ADC PARKS & GREENSPACE ARBORICULTURE

PLANNING APPLICATION: AW/287/14/TC

ADDRESS: 237 Manor Way Aldwick PO21 4HT

BRIEF DESCRIPTION: Reduce 1 No Oak Tree by 1m all round and reduce 4 No Birch Trees by 1.5m in height within the Aldwick Bay Conservation Area

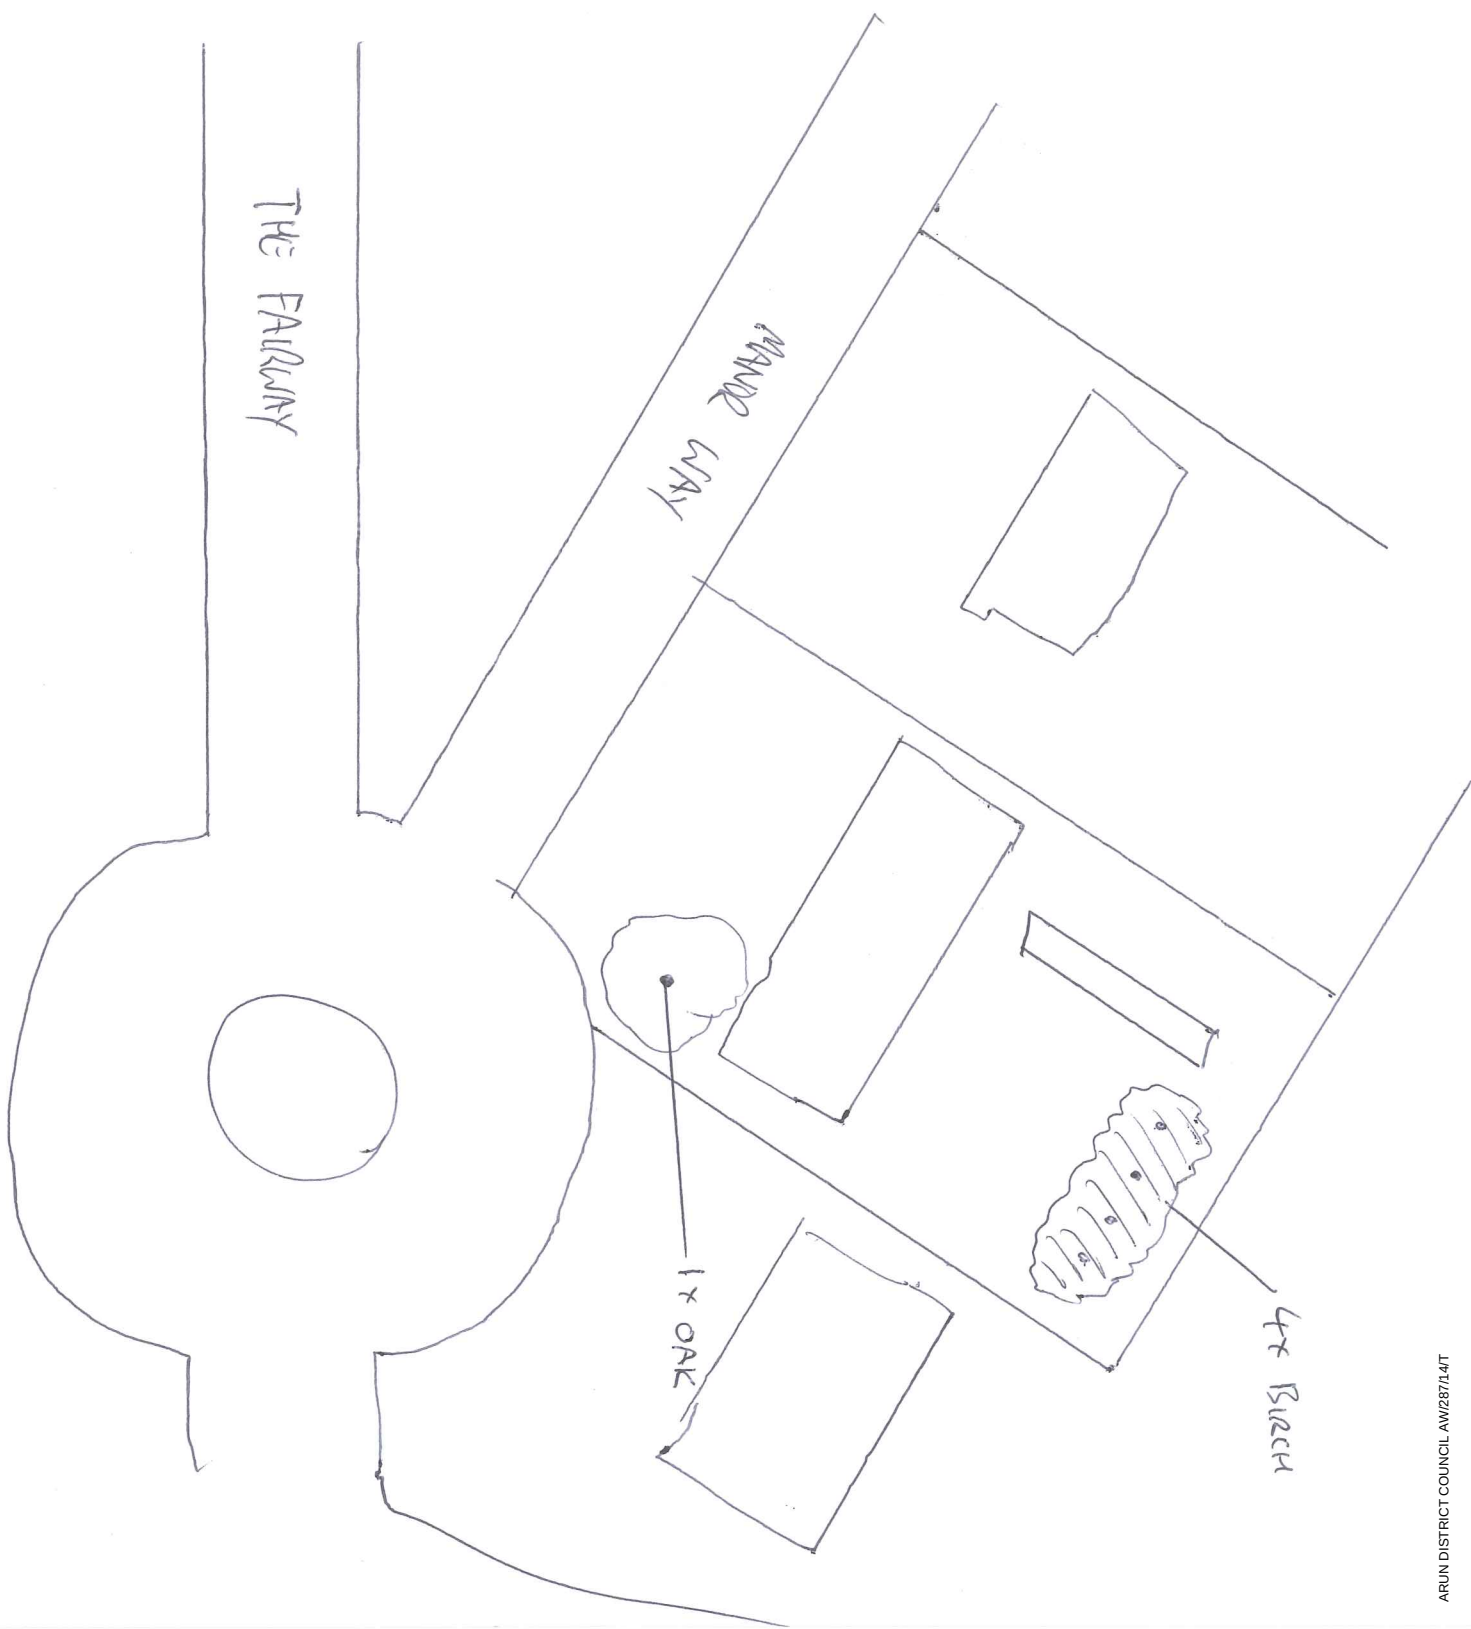
- The single oak (situated in the front garden of the outlined property) has clearly had a heavy reduction historically (this can be seen in the crown structure). The proposed operation will see a 1 meter reduction of this regrowth, which itself is currently 3 meters of lateral extension. As this operation is likely to increase the retention span of the given tree (as the old pruning unions are more likely to experience failures if the regrowth is left unchecked) it would be unsuitable to seek a TPO order.

- As for the 4 birch trees located in the rear garden of this property, it is apparent these individuals have been regularly pruned to the established height that has been applied for in this application. (this can be determined as the size of the limbs below the established pruning point are large, compared to the 1.5 meters of small diameter regrowth that is above the established pruning points. As this operation is likely to reduce the chance of failures occurring at the pruning points (and leaving open wounding) I would not see it necessary to seek a TPO order.

- **I would therefore have no objection to the proposed operations**, as they are likely to be beneficial to the overall health and vitality of the given individuals. Moreover the proposed operations would not indicate these individuals would require a TPO order to force conditions upon the applicant.
